CITY OF ALBUQUERQUE

RE: **Taos II @ The Trails**
Grading and Drainage Plan & Report
Stamp Date 7-13-16 (File:C09D00G1)

Based upon the information provided in your submittal received 7-14-2016, the above referenced Grading and Drainage Plan & Report is approved for Preliminary Plat with the following conditions:

### POND 'F-5' OUTLET RISER DETAIL

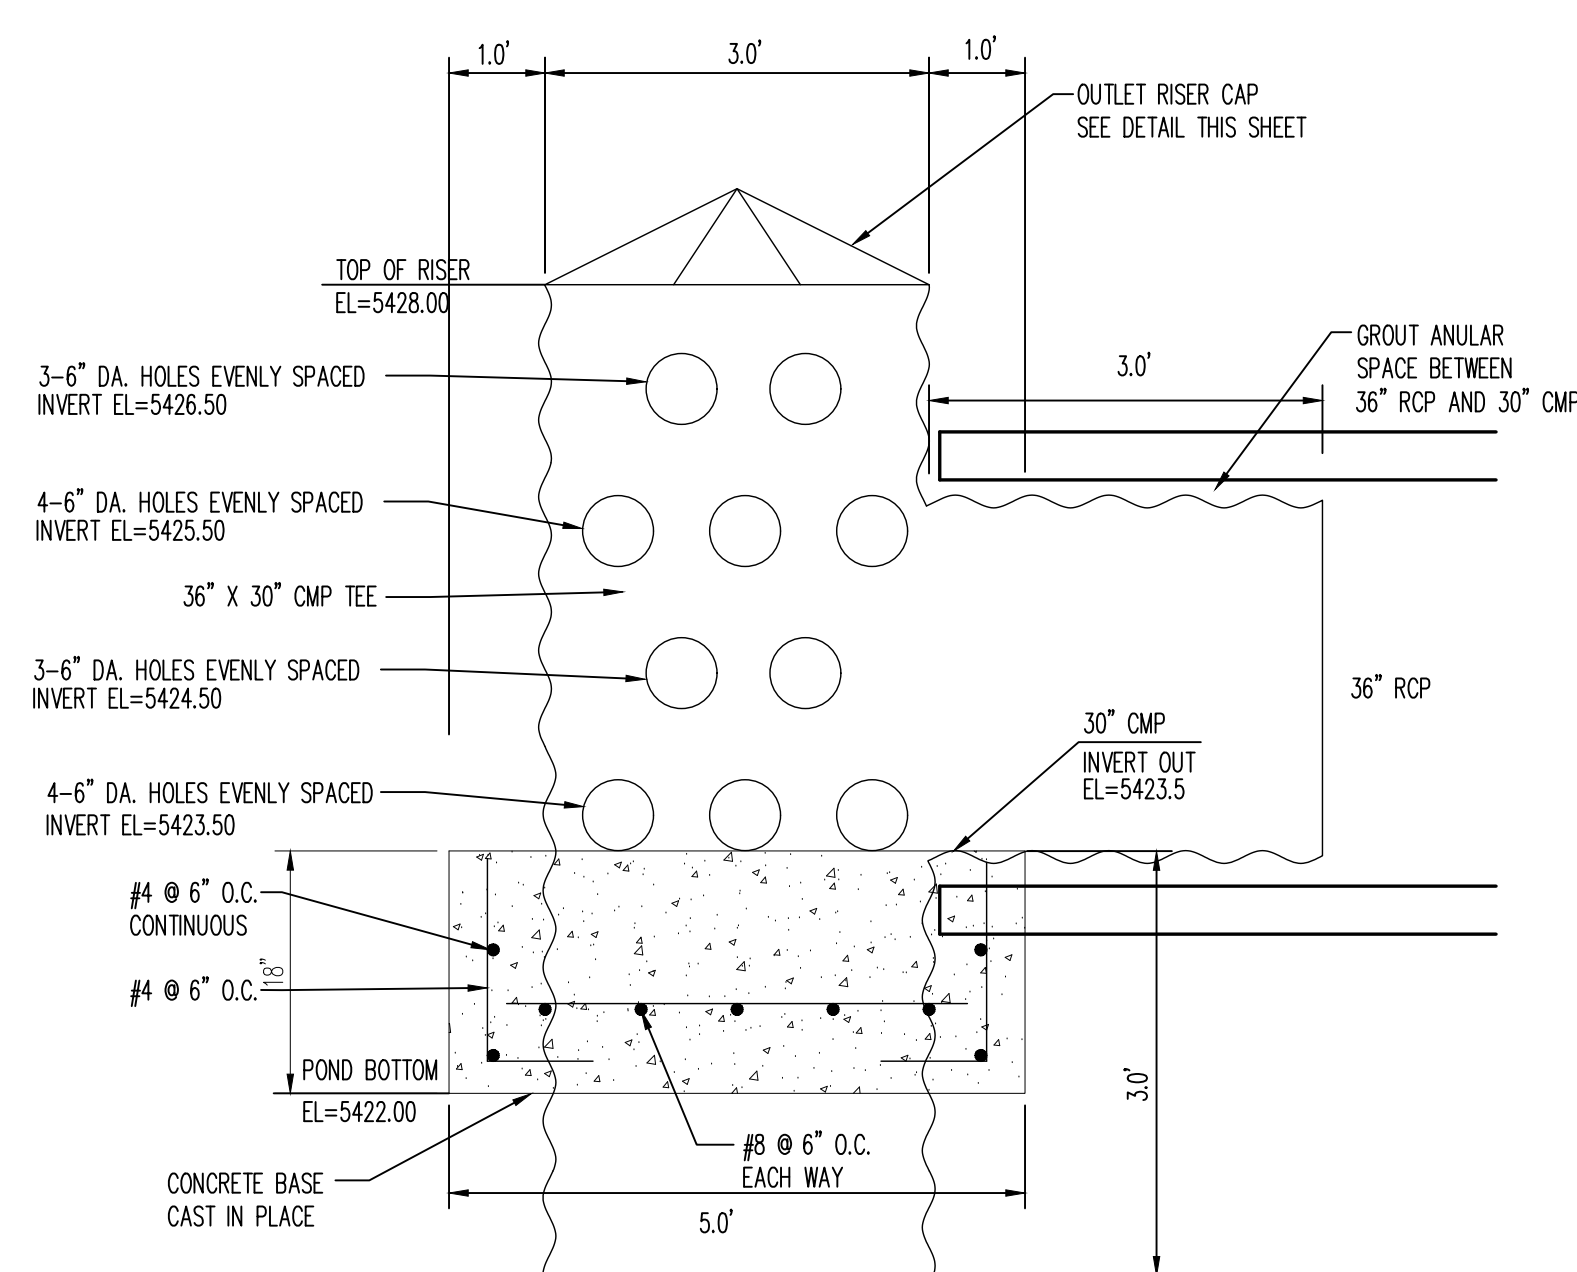
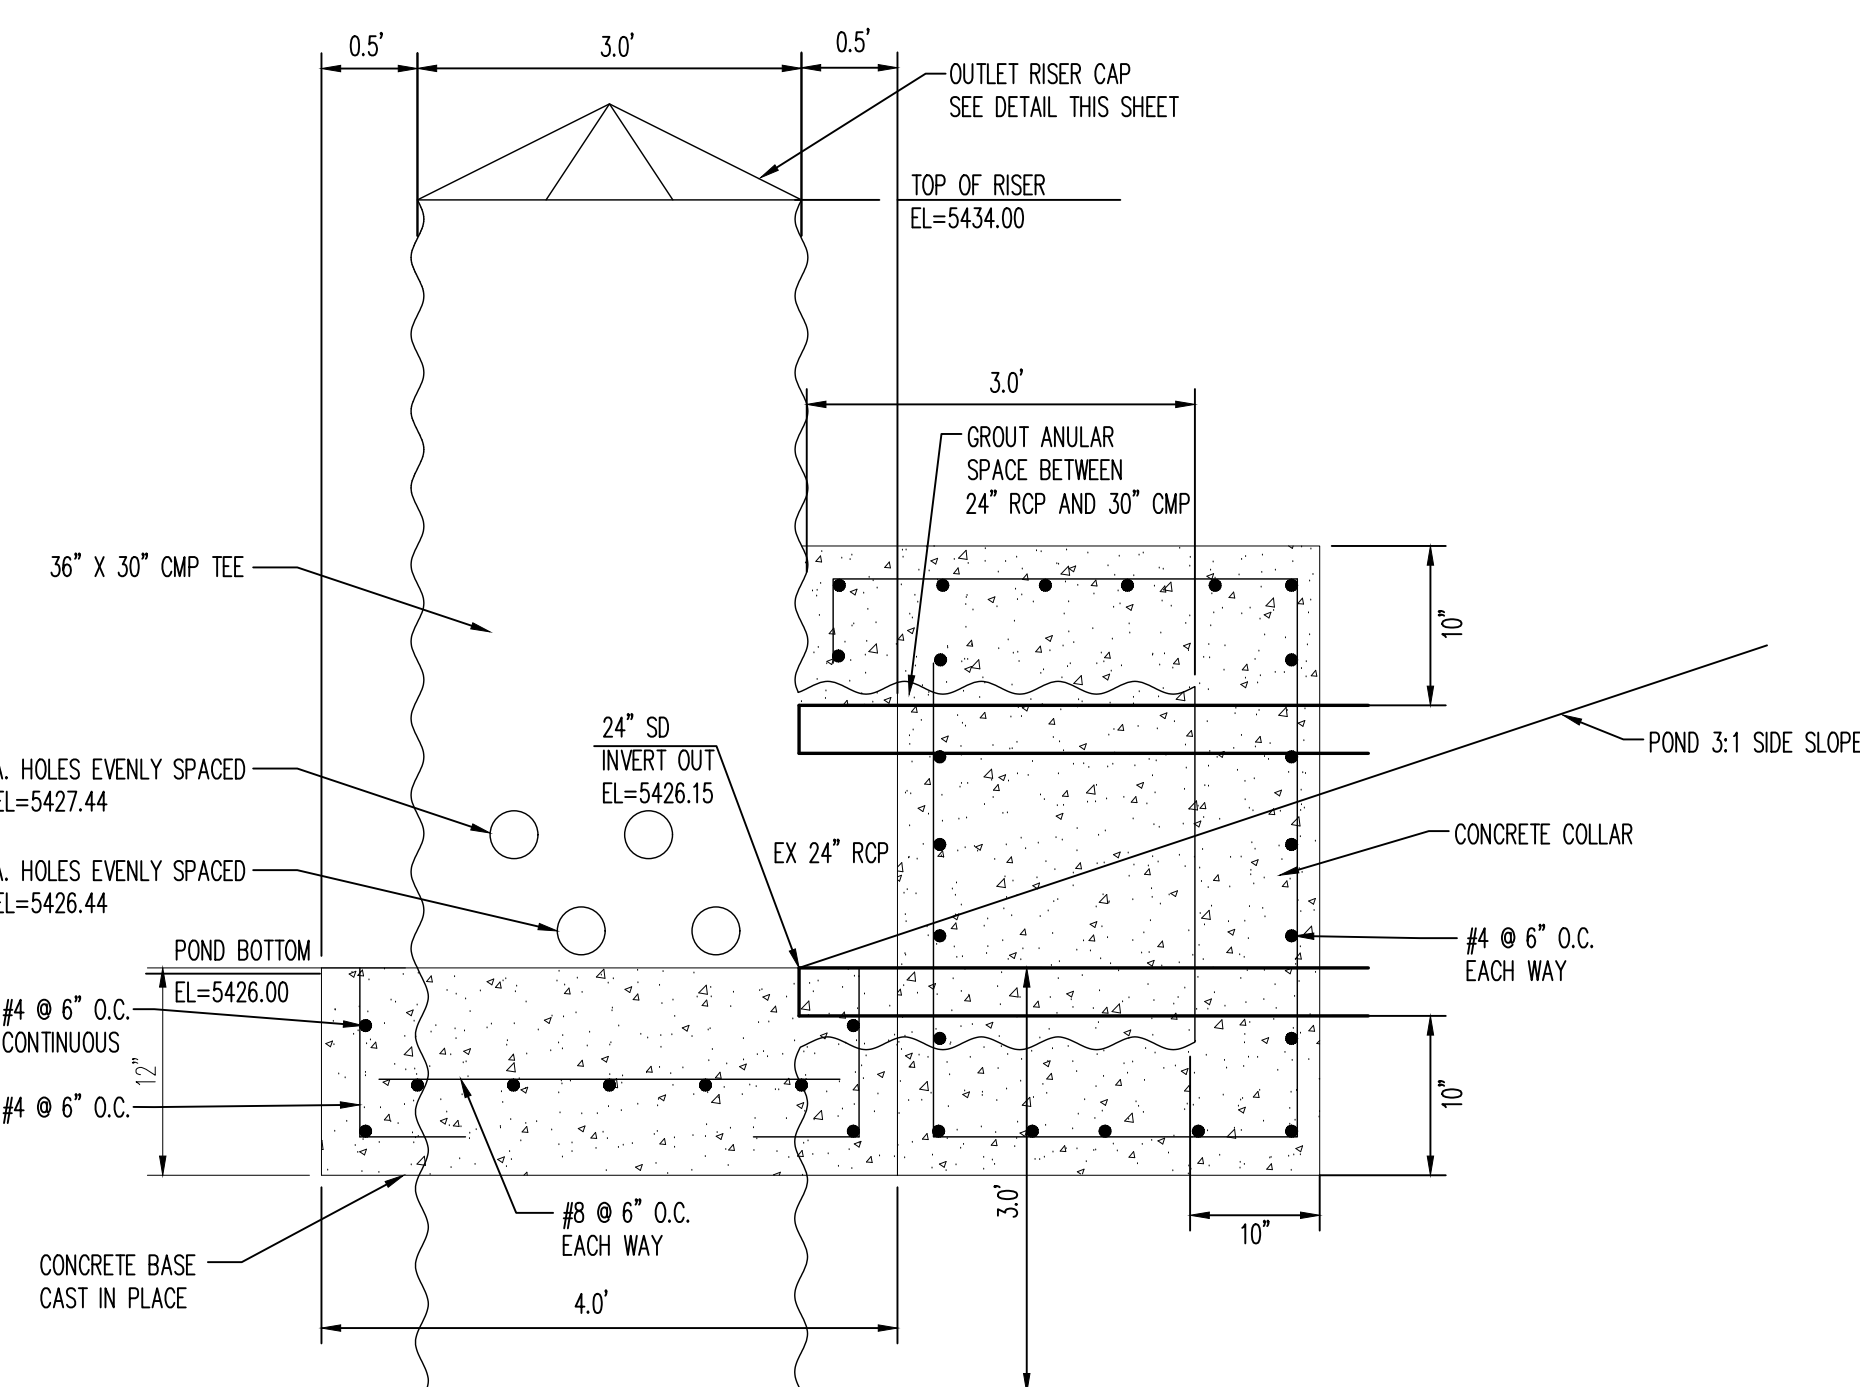
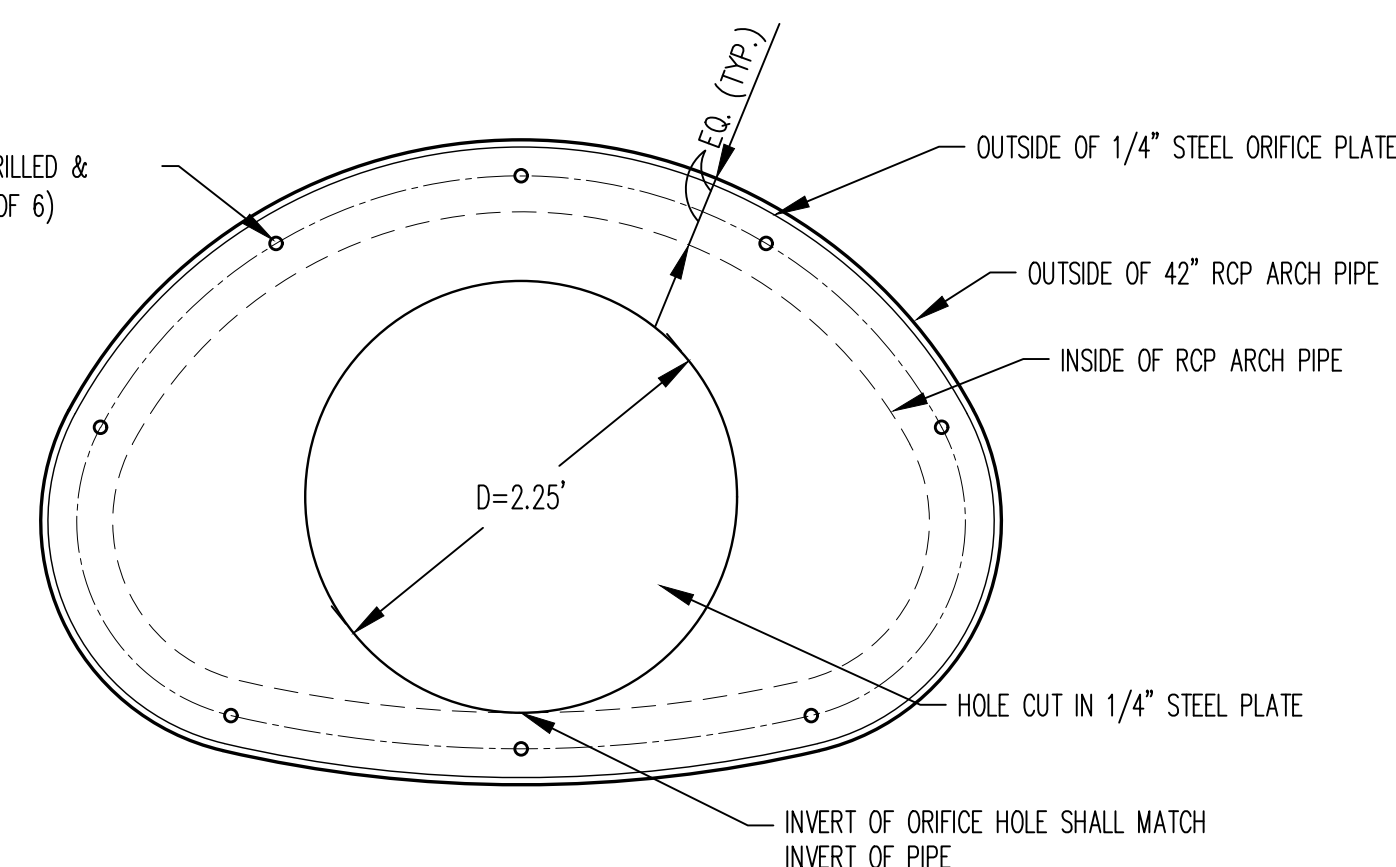
2. The improvements referenced on the Infrastructure List need to be shown on the Grading Plan:
 - a. The Improvements related to Ponds F, F5 and D. The orifice plate can be included by reference or as a specific note/exhibit of the improvements required.
 - b. The outfall conditions into Pond F5. Note that the Drainage Master Plan elevations are based on NGVD 29 datum.
3. It is not clear where the wall drain detail will be used since it appears that all lots drain to the roadway. Any planned rear-lot ponding would require an easement.
4. An approved ESC Plan will be required.
